Your Ref
LU/17/19/DOC
Our Ref
PLAN-026633
Date
15/02/2019

Proposal: Approval of details reserved by condition imposed under LU/47/11/ relating to conditions 10-surface water drainage, 12-discharge of water courses or the culverting, diversion, infilling or obstruction of any watercourses & 13-foul water drainage.

Site: Land North of Toddington Lane, Littlehampton, BN17 7PP.
LU/17/19/DOC

DETAIL D - 01
LONG SECTION THROUGH OUTFALL PIPE TO PERMEABLE SUB-BASE

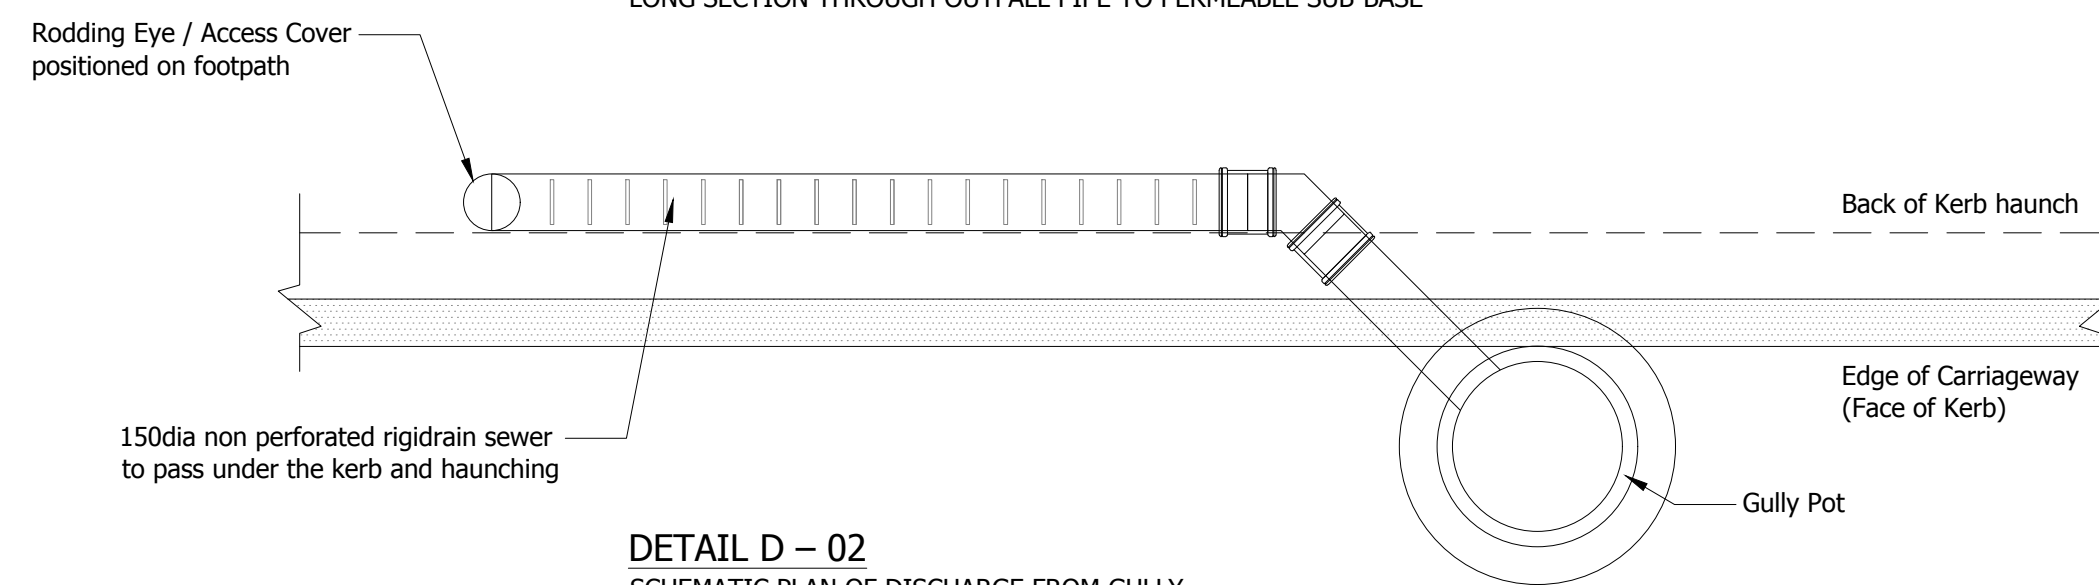
Southern Water would have no comments to make with regards to means of surface water discharge to watercourse and access to this feature. However, the details of the surface water drainage as covered by condition 10 do not seem to be satisfactory. The surface water drainage, although proposed to be designed to adoptable standards, does not seem to comply with such standards and Southern Water requirements. The matters that will not be considered as adoptable by Southern Water may include: online attenuation facilities; connection of swales, soakaways, filter drains and other features introducing land drainage and

groundwater to adoptable drainage; construction of tanked permeable paving and attenuation/ storage tanks over sewers offered for adoption.
